From: Kevin Eaton [REDACTED]
Sent: 15 July 2021 09:00
To: Kathryn Welch
Subject: Re: K/12/21/NMA Flint Barn
Attachments: NMA - Elevations - Original - No Scale - 12 Jul 21.pdf; NMA - Elevations - Proposed - No Scale - 12 Jul 21.pdf

Subject: K/12/21/NMA Flint Barn

Drawings
Proposed Elevations

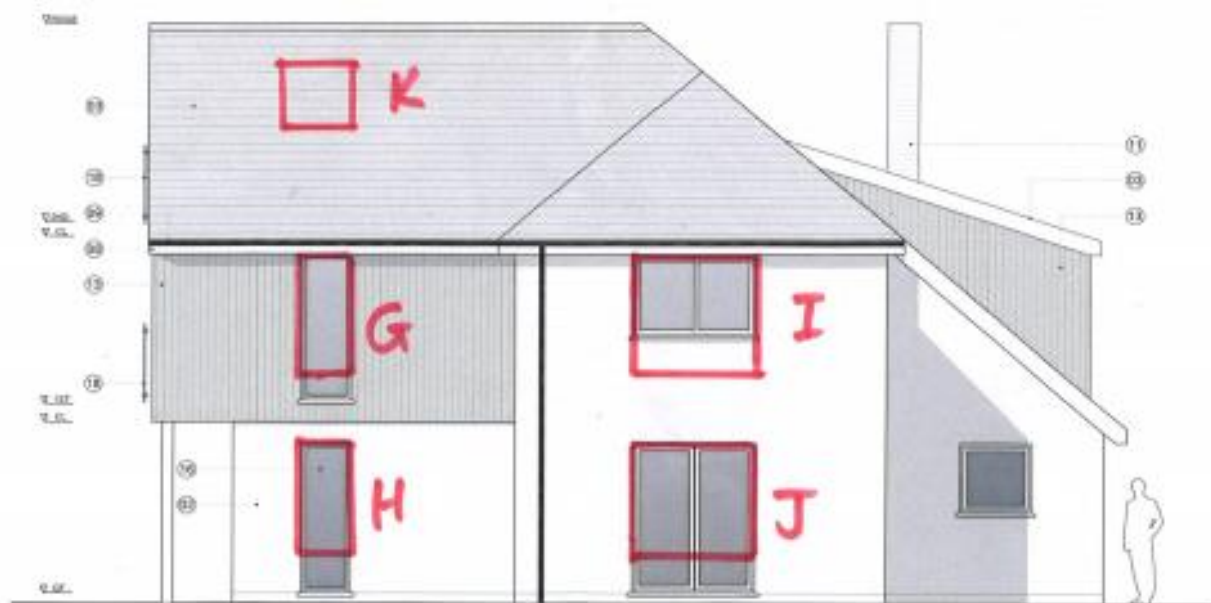
Unfortunately not, the proposed plan is still showing the scale bar and labels under all of the elevational headings when I open it up.

I just wanted to check that the email below had been received. I understand the predicament with the scaling of the plans but at the moment with a scale still showing the plans are incorrect and I therefore can't approve them unless changed.

I just had a chance to discuss the application with our validation team. Mrs Mason who originally validated the application has told me that she requested the scale information be removed from the plan detailing the changes to the windows, which she thought had been done. I can see the scale bars have been removed, my issue is that the title to each part of the plan i.e. proposed XX elevation still states the scale of the drawing to be 1:50.

Could I request, for the avoidance of doubt, that you cross this information out to each of the proposed elevations and re-send the plan to me. Just to be clear, I only need the elevational plan showing the proposed amendments to windows A-N altering.

Error on my part. Please see attached with scaling removed.

Apologies for the delay but please note the attached elevations, as requested, without scale references. Hopefully these are ok.
